January 9, 2024

**Re: Sage Plaza Storage
Erosion and Sediment Control Plan
Engineer's Stamp Date 1/4/24 (M09E012B)**

Based upon the information provided in your submittal received 1/5/2024, the above-referenced ESC Plan cannot be approved for Grading Permit or Building Permit until the following comments are addressed.

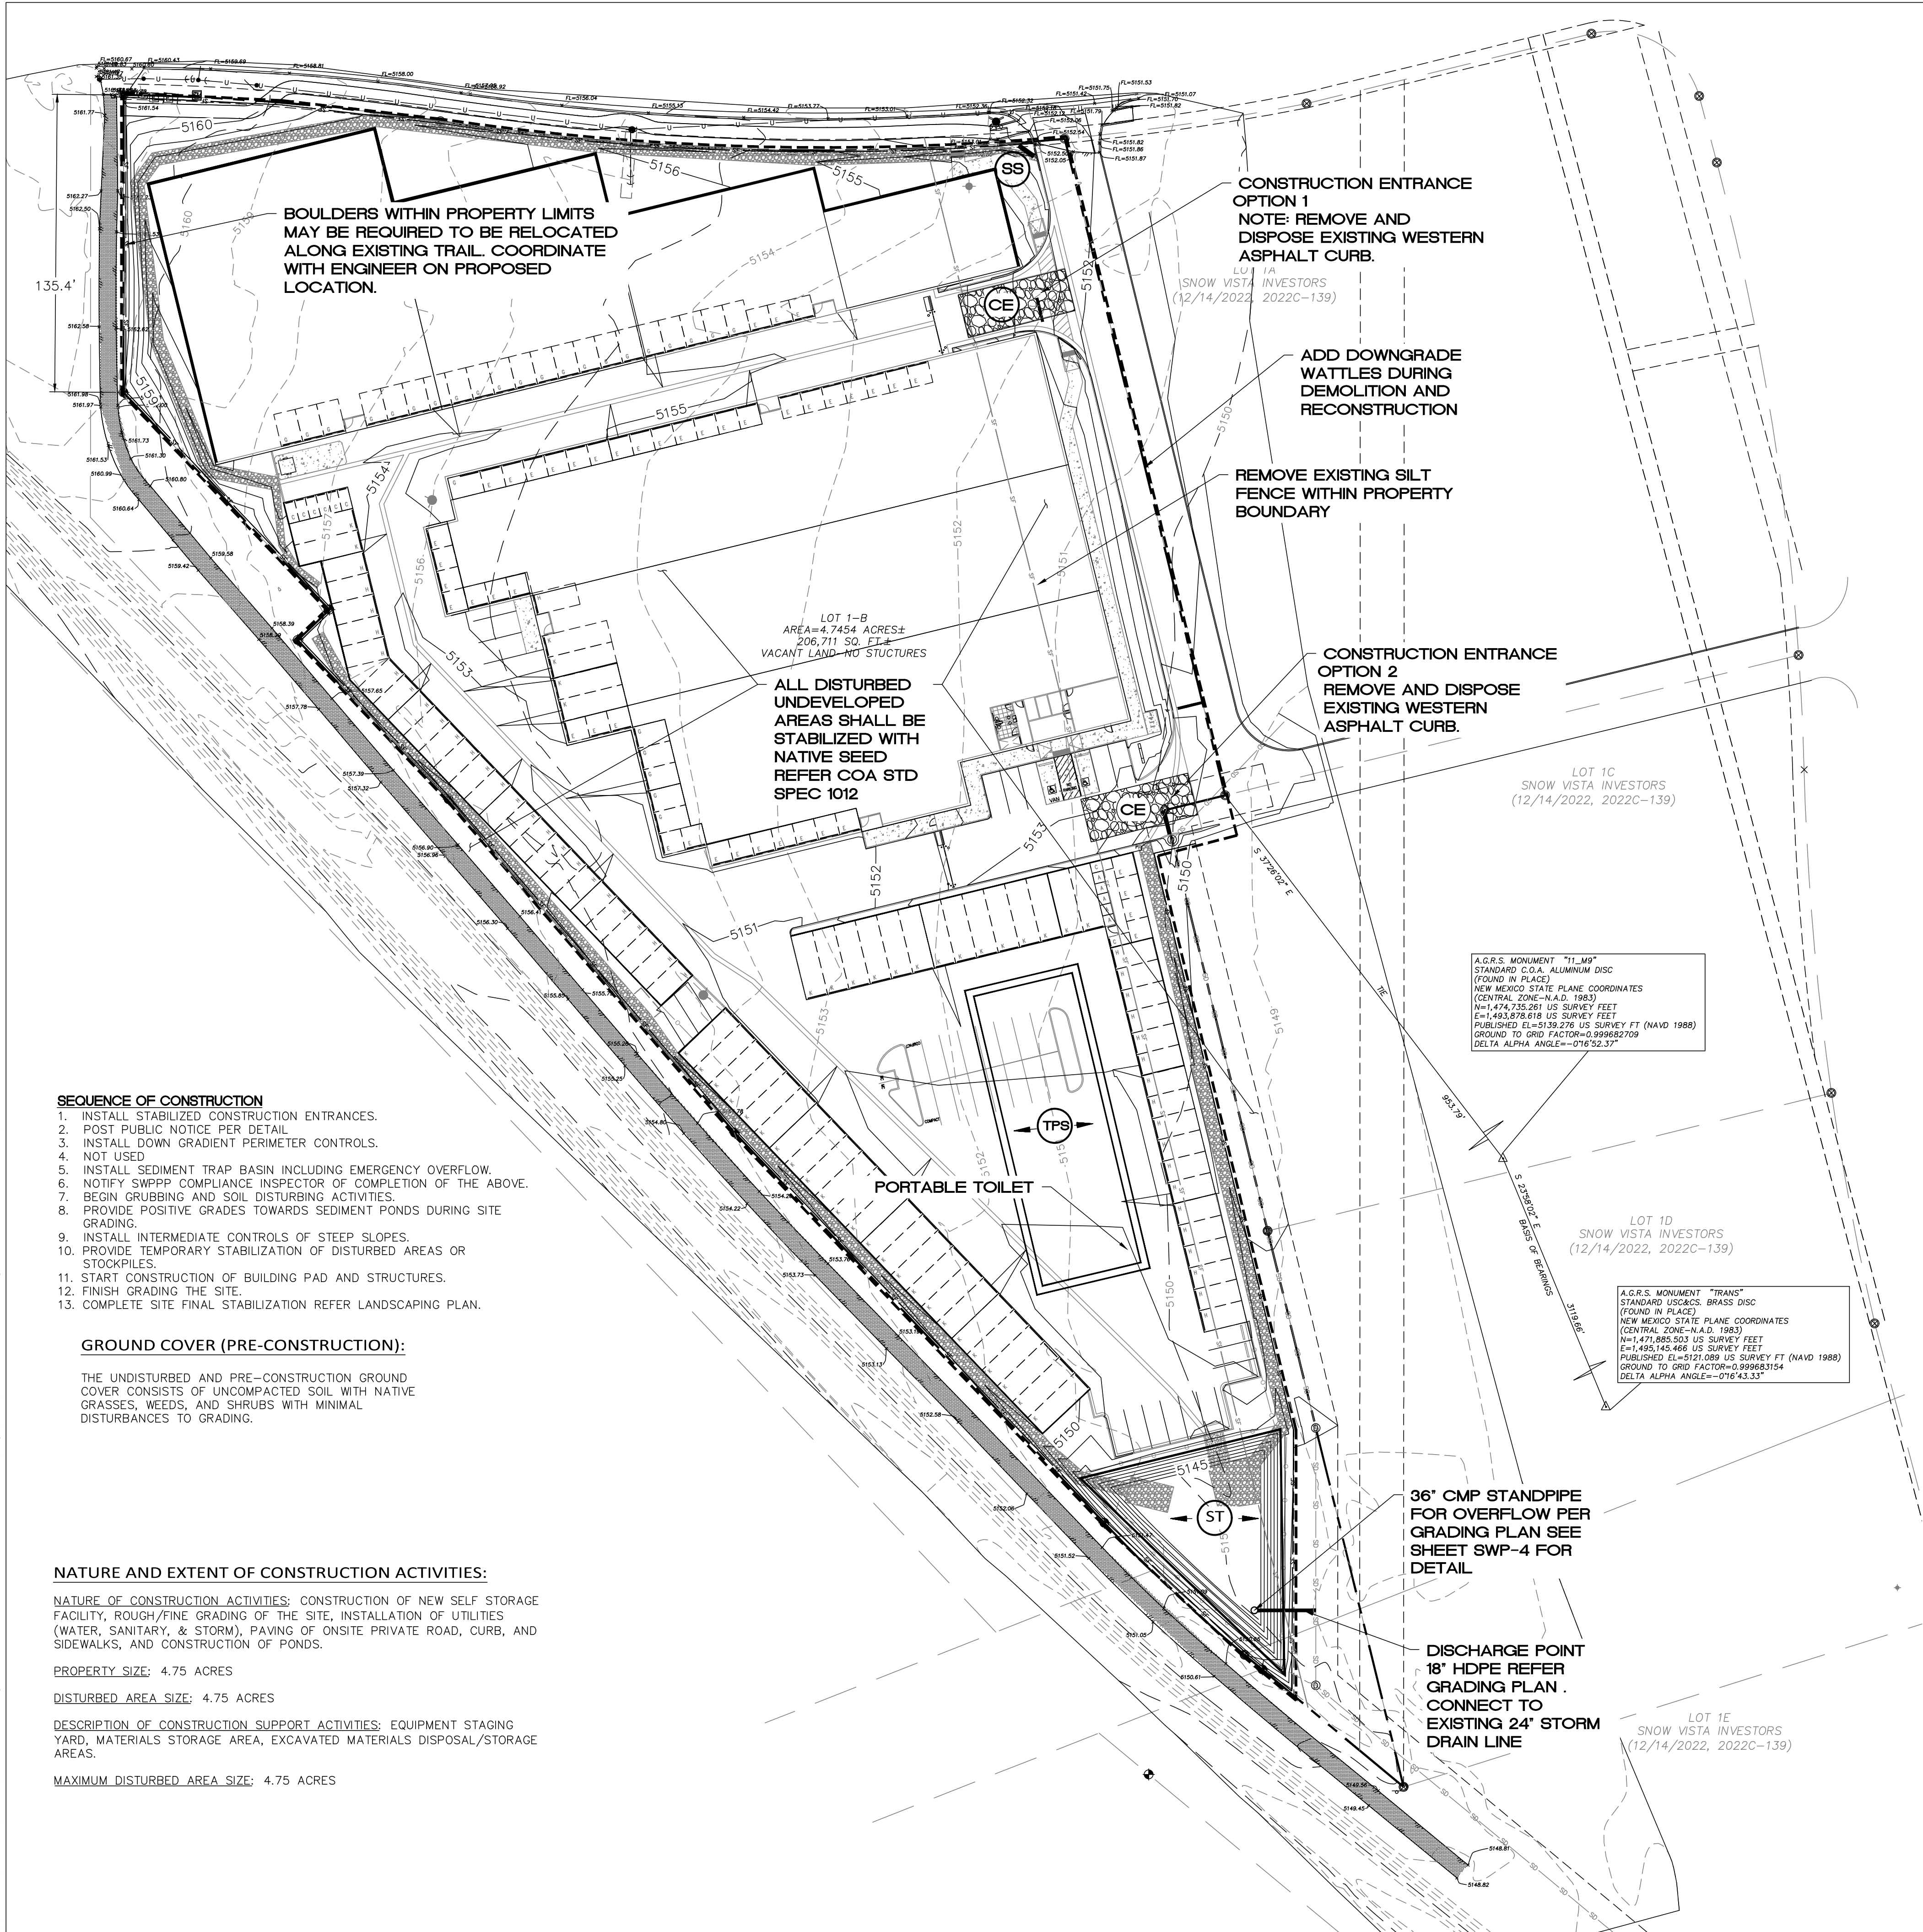
4. The SWPPP must include site-specific interim and permanent stabilization per CGP 9.6.1.c.i. Provide a specification on the ESC Plan along with schedules for implementation per CGP 2.2.14. Label areas where existing vegetation is to be preserved and not graded at this time. Label areas to be stabilized with landscape rock (all areas in the public ROW) and show typical section and specifications. Label areas to be stabilized with vegetation and provide details and specifications.
